Letter of Intent Site Development Plan

Trenton B Urban
6365 E Platte Ave.
Colorado Springs, CO 80915
Project Name: Wirenut

Letter of Intent_V1.pdf Markup Summary

① SITE PLAN
SCALE: 1"=30'-0"

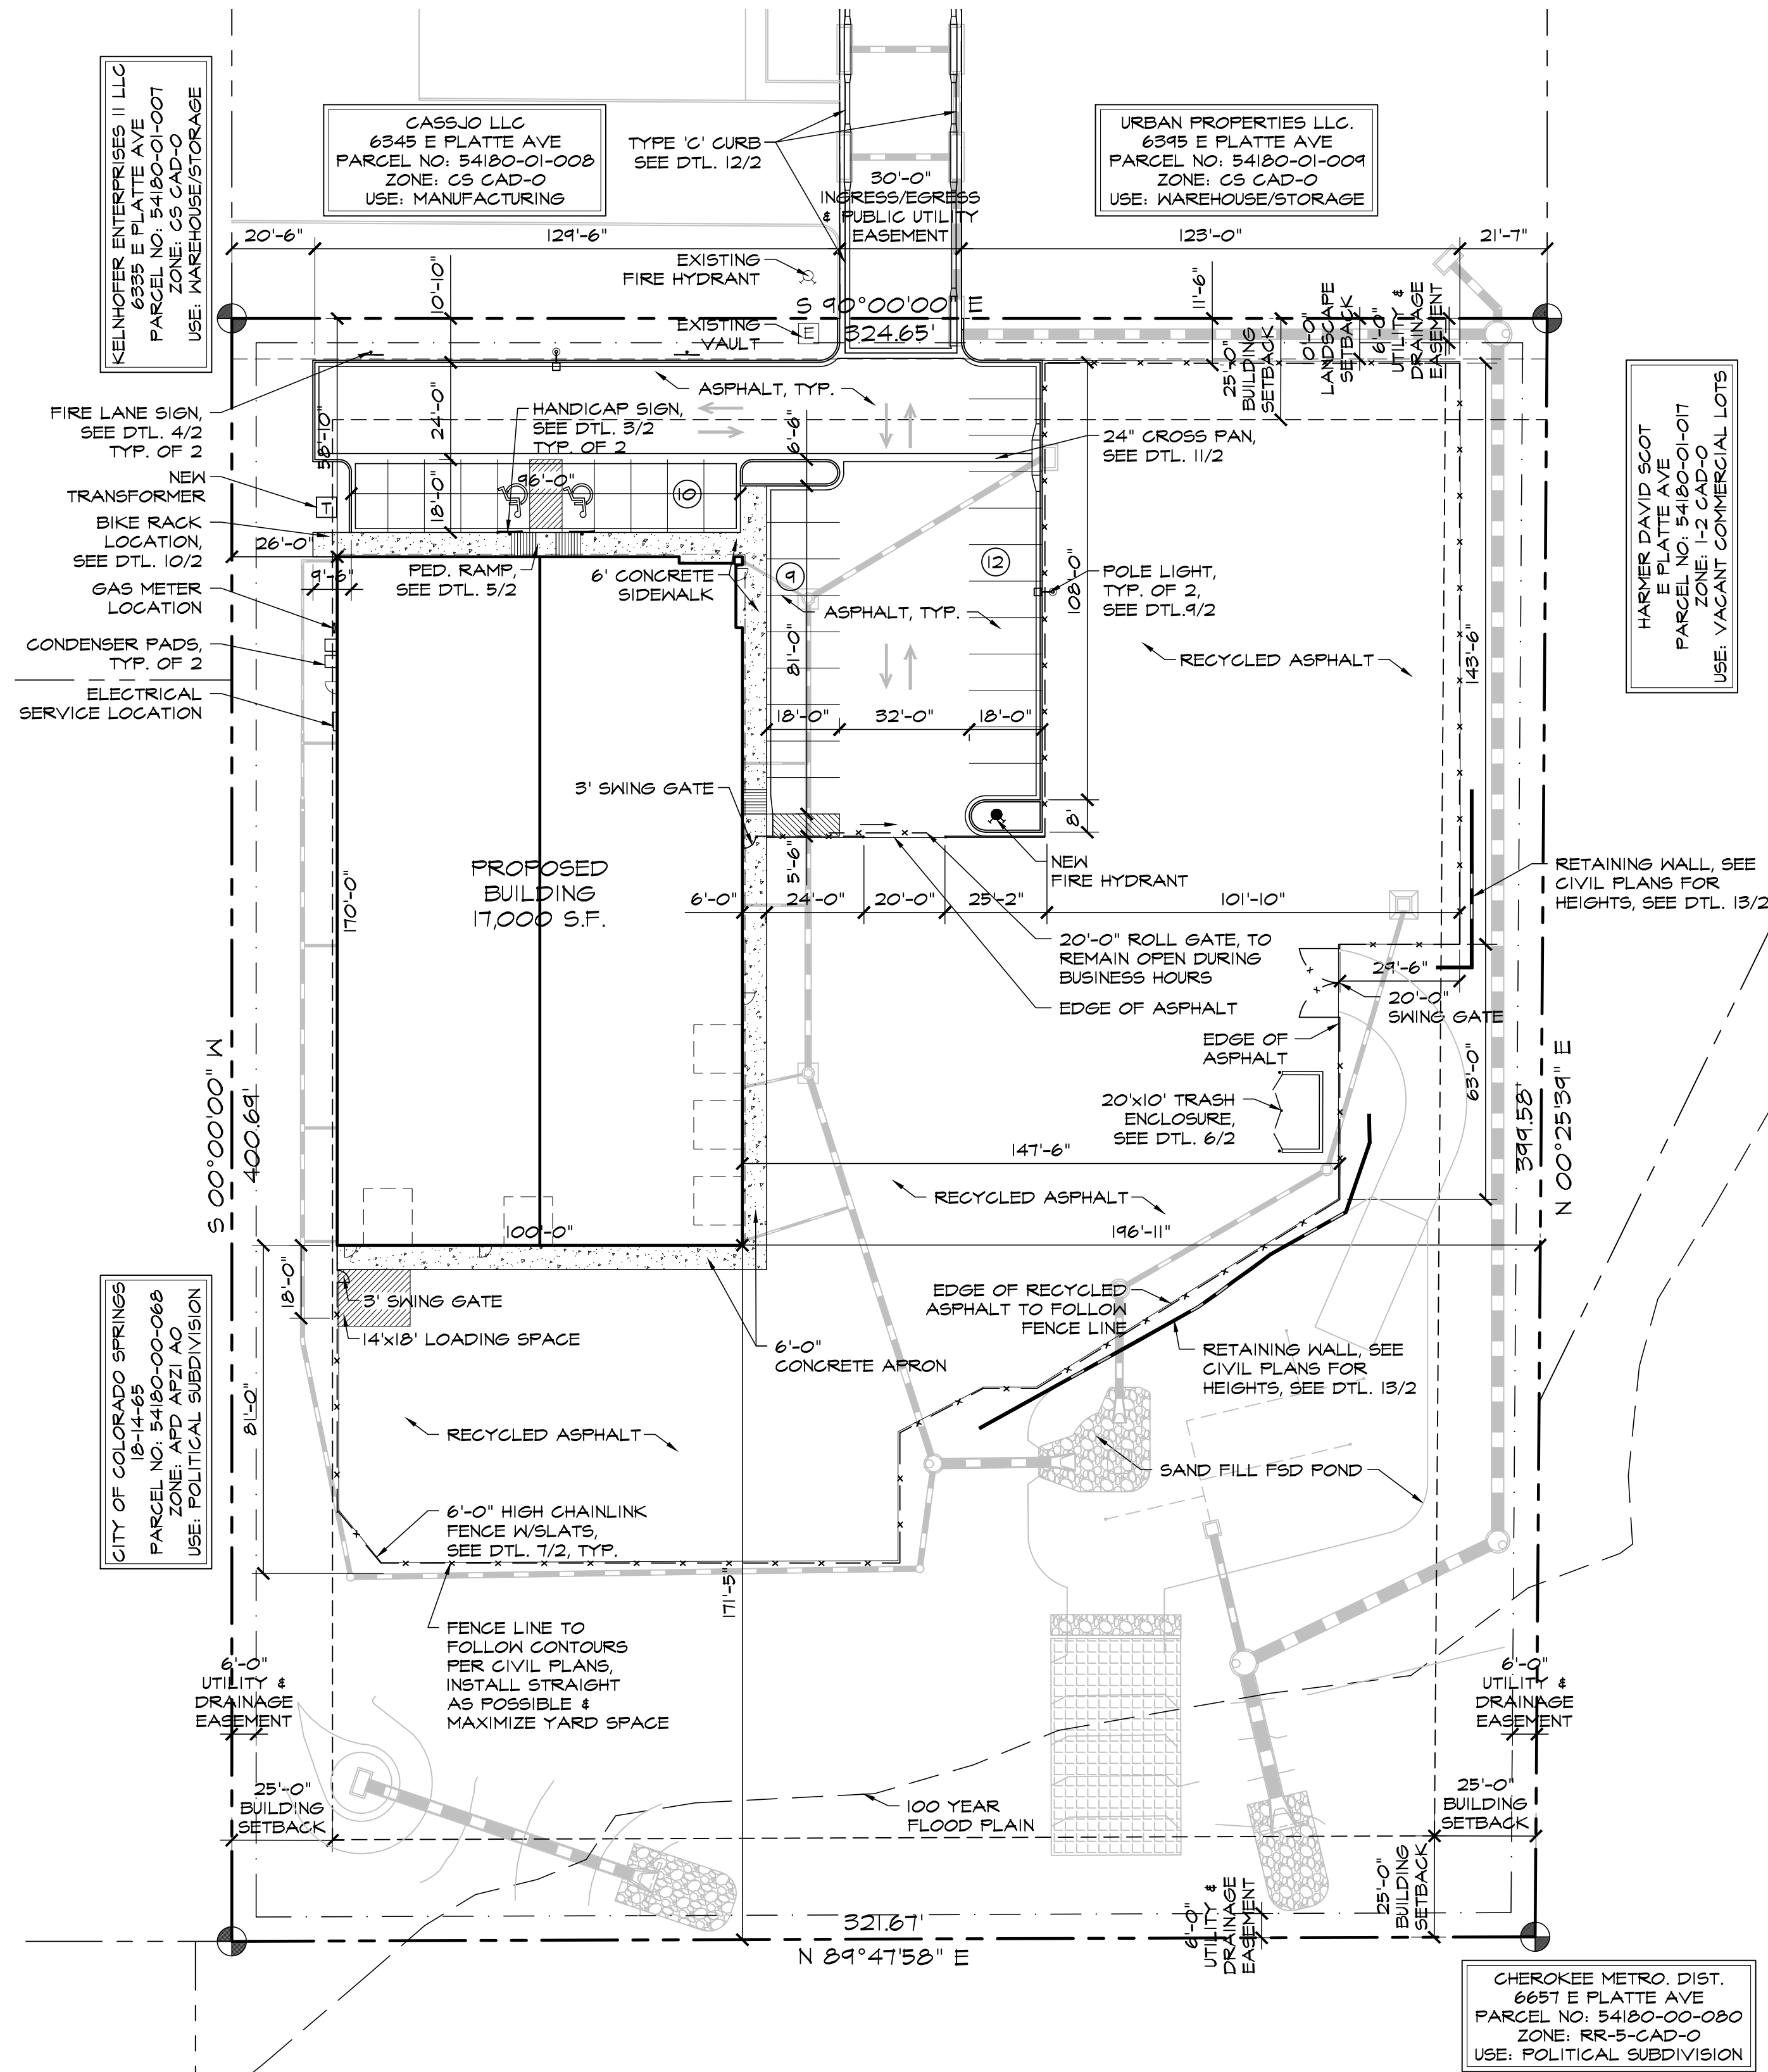
Resolve the discrepancy. Be sure to be consistent on the Site plan also.
